January 12, 2021

**RE: #1 and #2 Cedars airspading 2009-183 7238 SE 32<sup>nd</sup> Street**

This is an addendum to the August 2020 arborist report for this site.

DRAWING NO:
C1.0
APN 531510-0775
2009-183

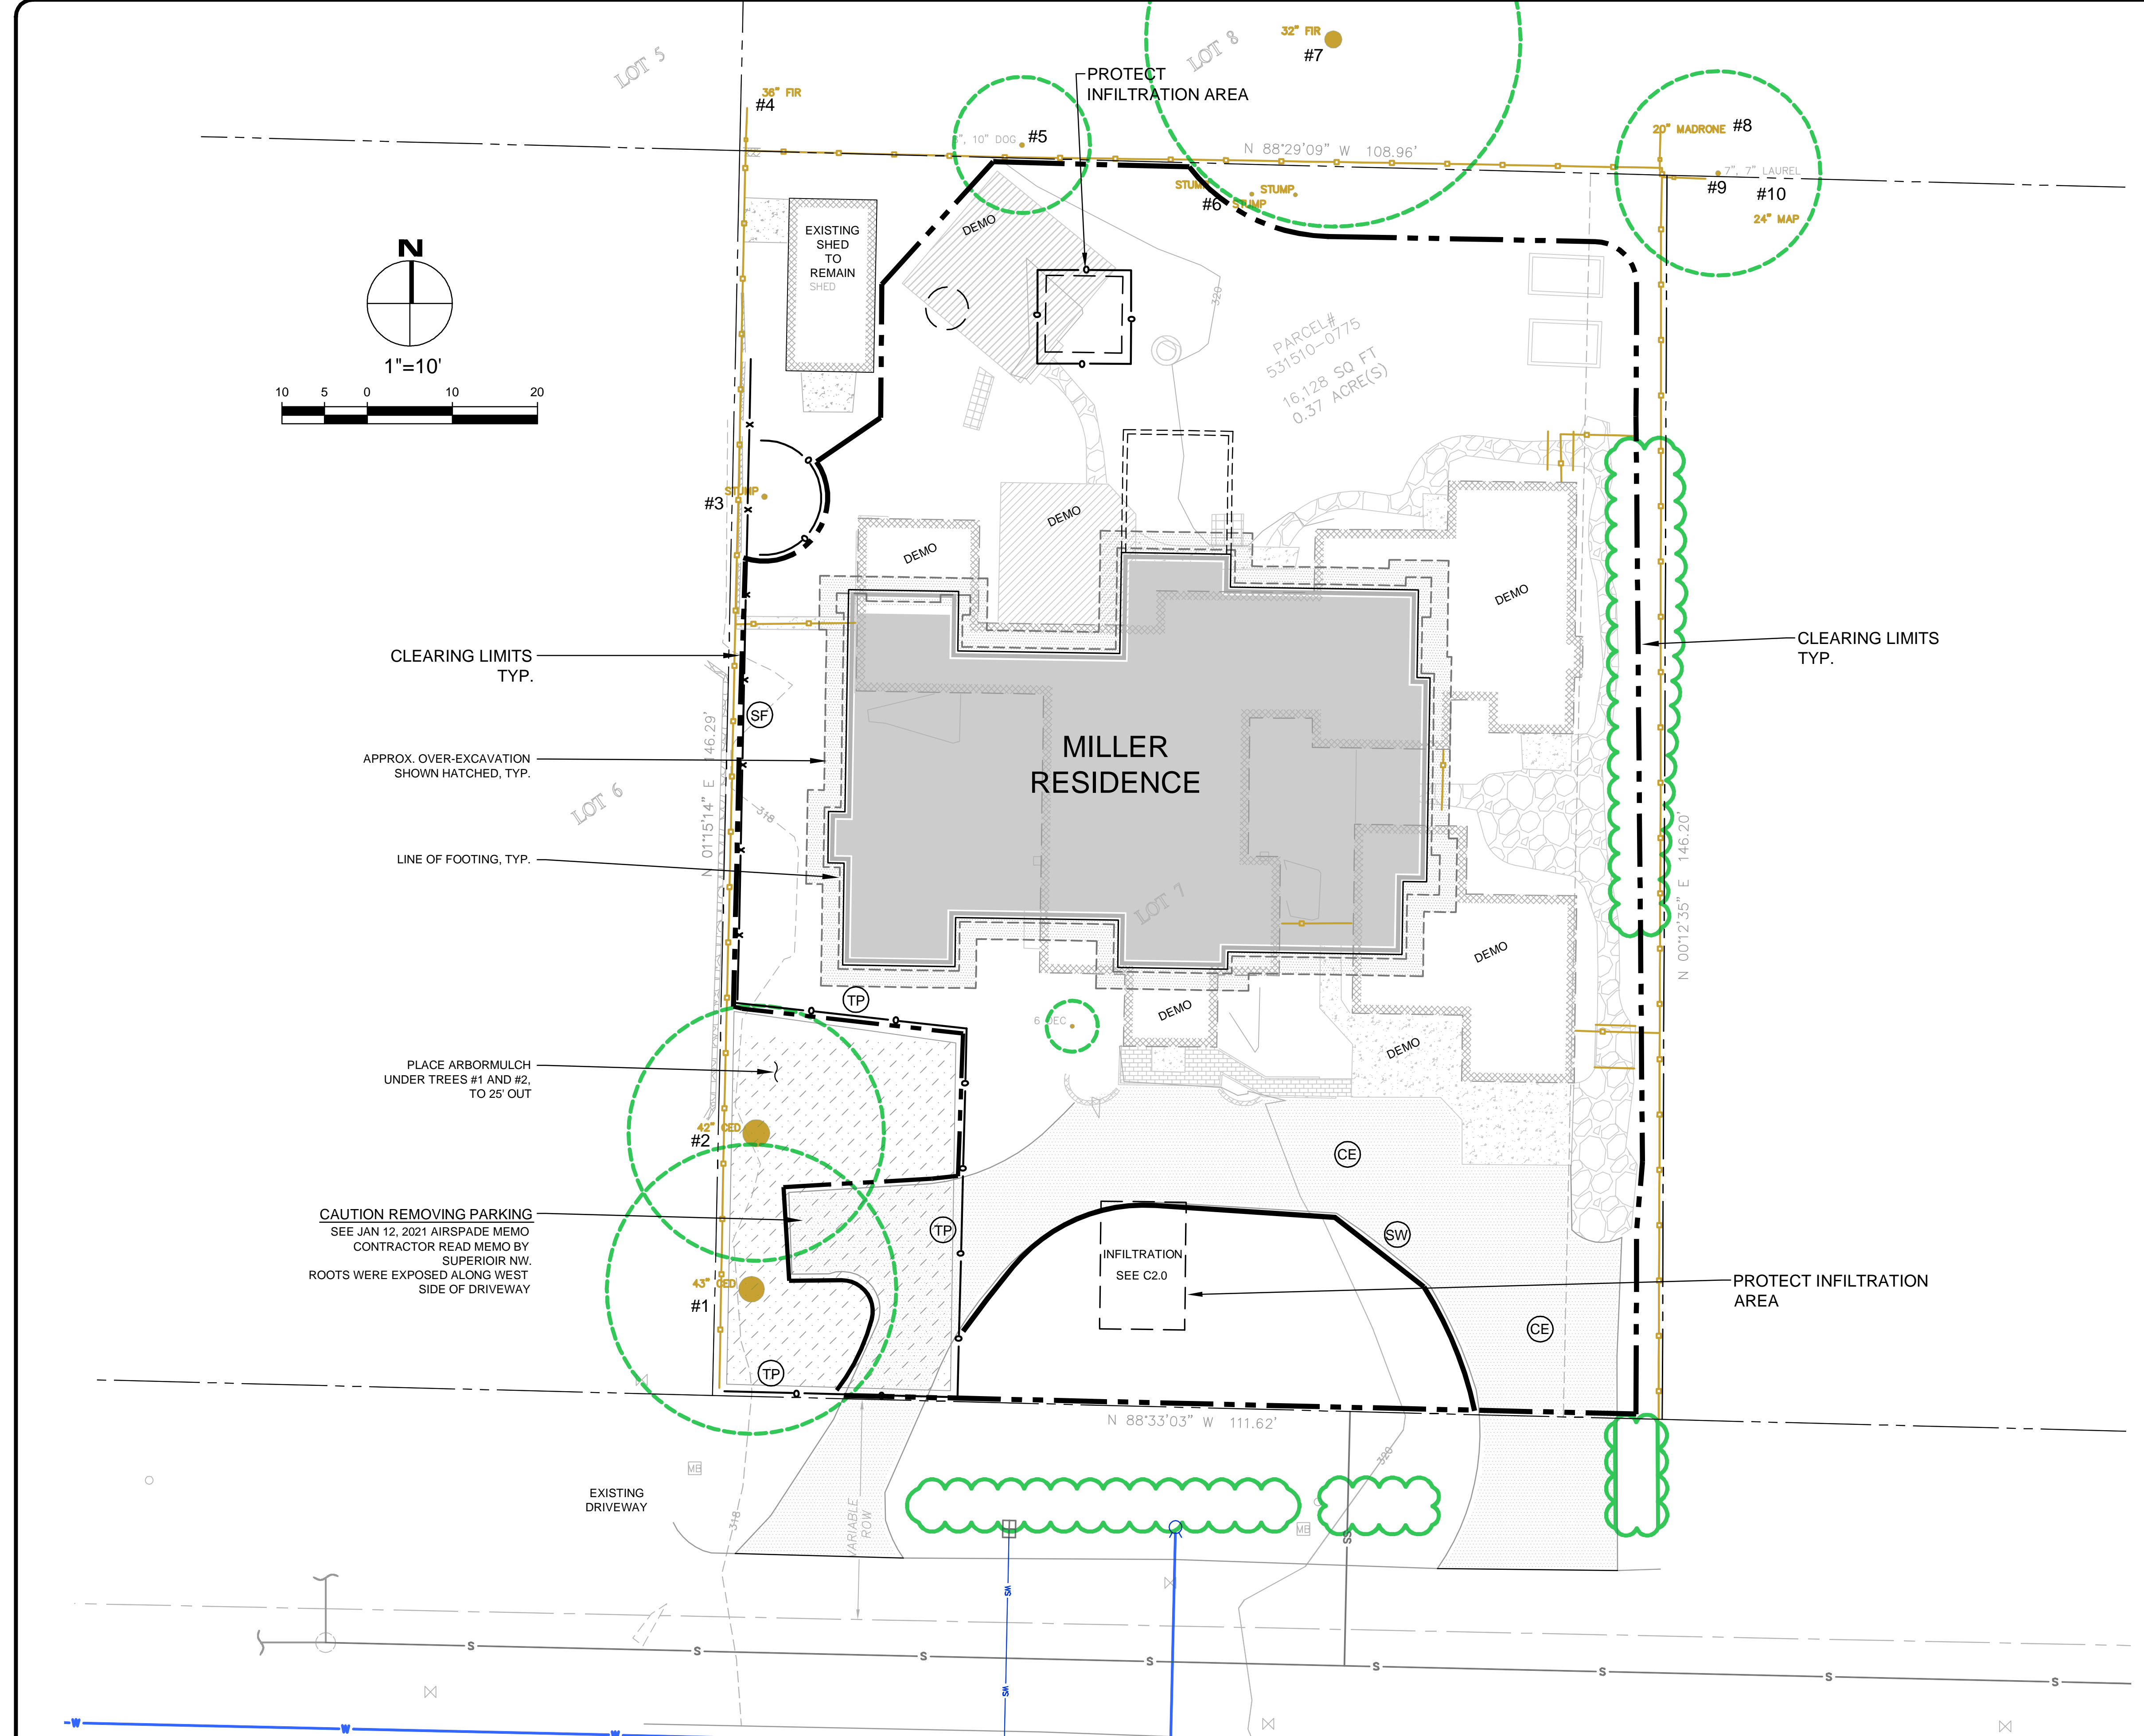
On January 11, 2021 airspading was completed to exposed the roots along the west side of the driveway and the north side of the #2 tree. Figure 1 shows where the work was done.

Very few feeder roots were seen alongside the driveway (Figure 2). It should be completely fine to raze this section with heavy equipment. The parking space portion will have to be lifted quite carefully as there are definitely roots beneath it.

This area will have to be fenced prior to demolition to absolutely minimize root impact. Before excavation for the new foundation is started the cut line will have to be laid out with thought to preserving the maximum of roots present. The minimum possible clearance should be allowed for the foundation forms (8-12" rather than the 24-30" normally given) in this region. Once this line is established the roots will have to be severed cleanly with a chop or reciprocating saw.

The protection fence will then be set at that line and will remain undisturbed for the remainder of the project. The fence will turn south where the entrance walk will be sited for the new home as shown in Figure 5. Once the asphalt is lifted the entire area will have to be filled with 6-8" of arbormulch to protect the roots and aid in the long term recovery of the trees.
